PRELIMINARY DRAINAGE REPORT FOR BRADLEY POINT FILING NO. 1

EL PASO COUNTY, COLORADO

PCD-ENGINEERING REVIEW COMMENTS
IN BLUE BOXES WITH BLUE TEXT

PCD Project # ~~70-XXX~~ **MS-21-002**

GRADING AND EROSION CONTROL PLAN
DECEMBER 2020

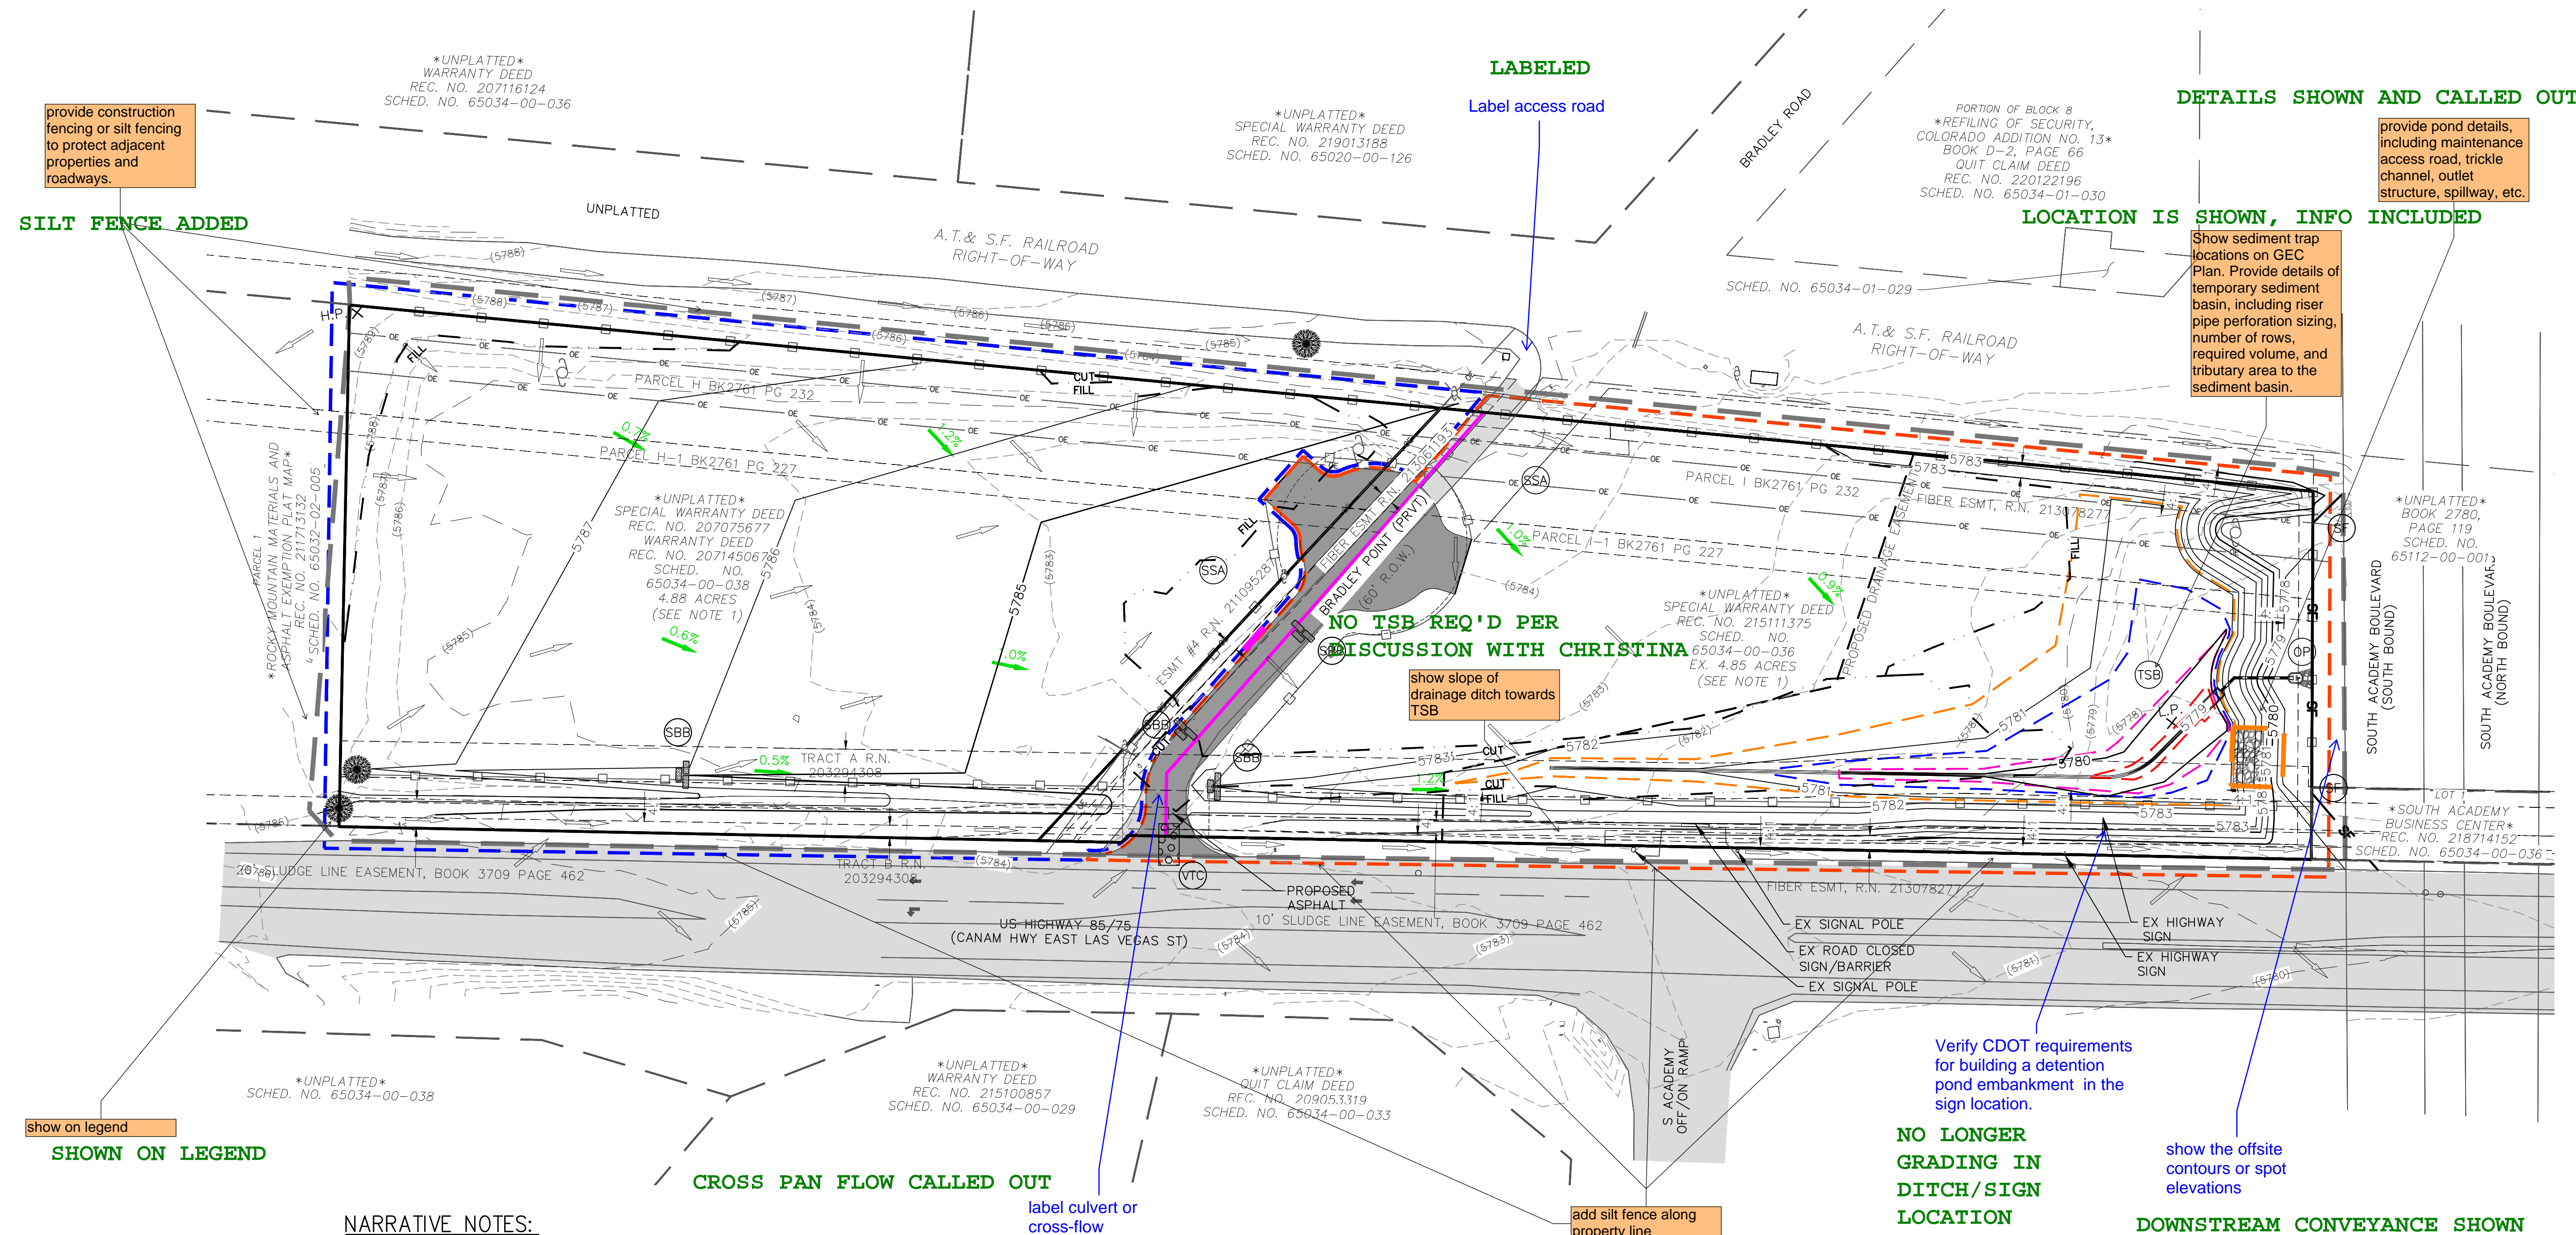
The grading plan shows regrading - will this just be gravel?

how does it cross
the access road?
